## L1.1

need to schedule a meeting to discuss the Landscaping. Now that property lines are established and per the Meridian Crossing Second Amendment to Meridian Crossing Maintenance Agreement and Declaration of Covenants, Conditions, and Restrictions, under (a) which includes landscaping that must be installed by Owners on their Lots, at their expense.

C4.0

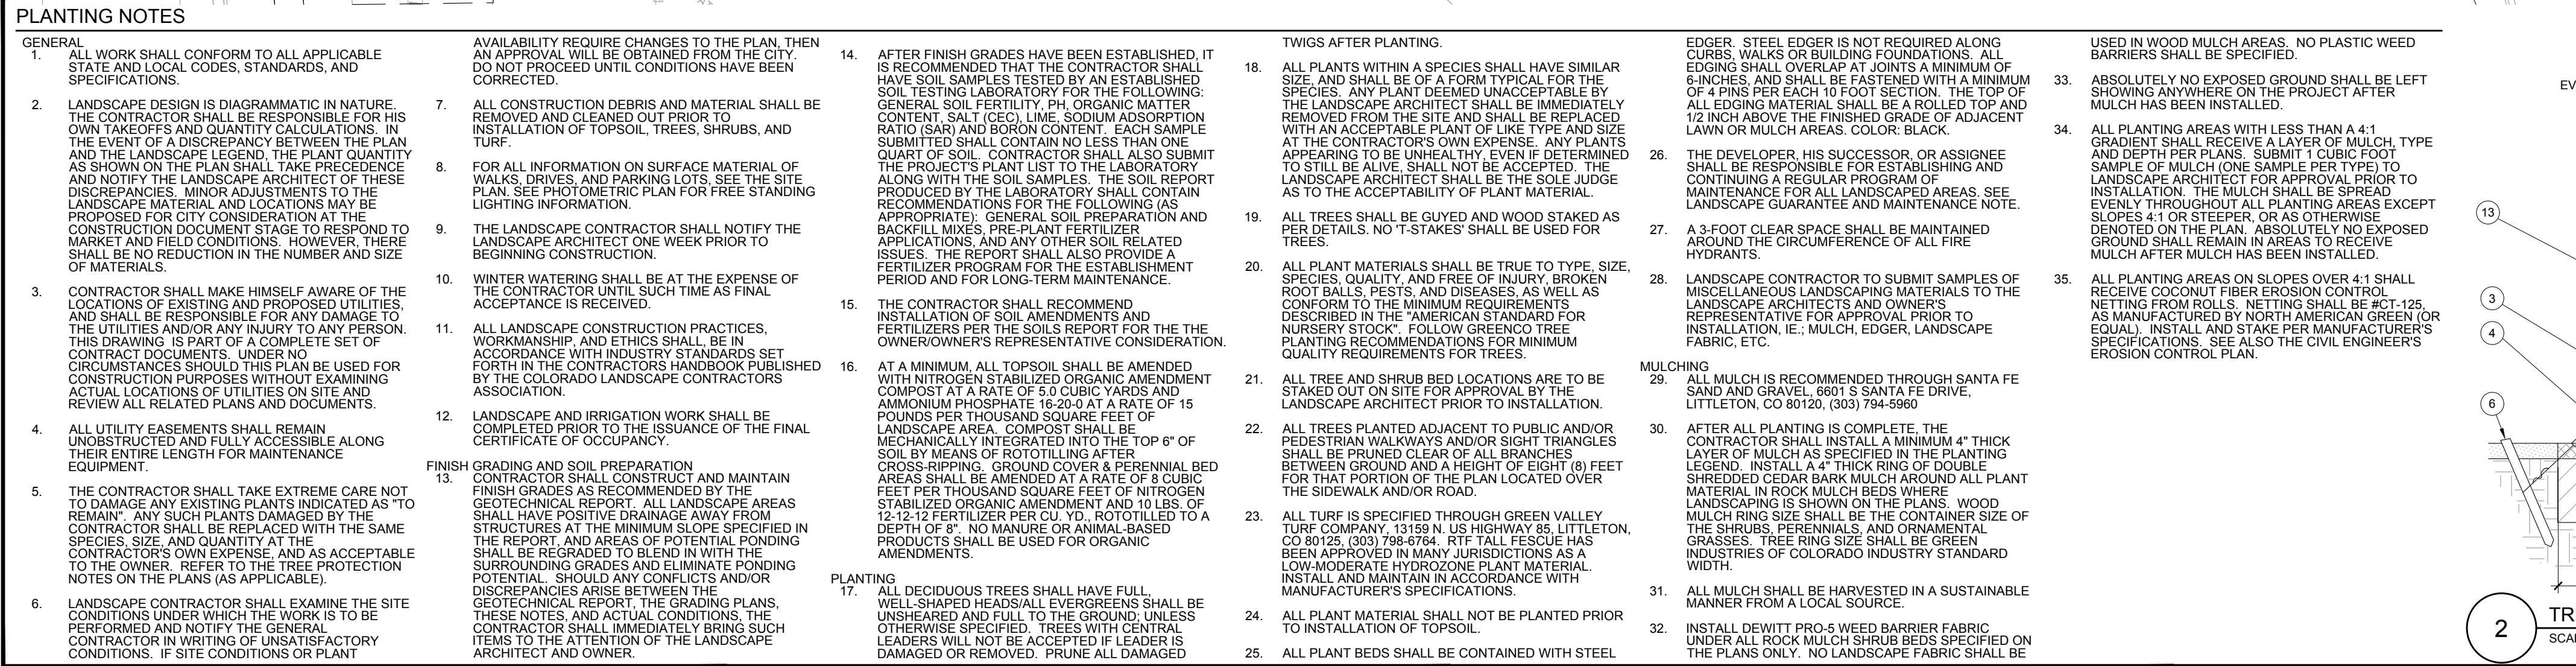
Locked (1)
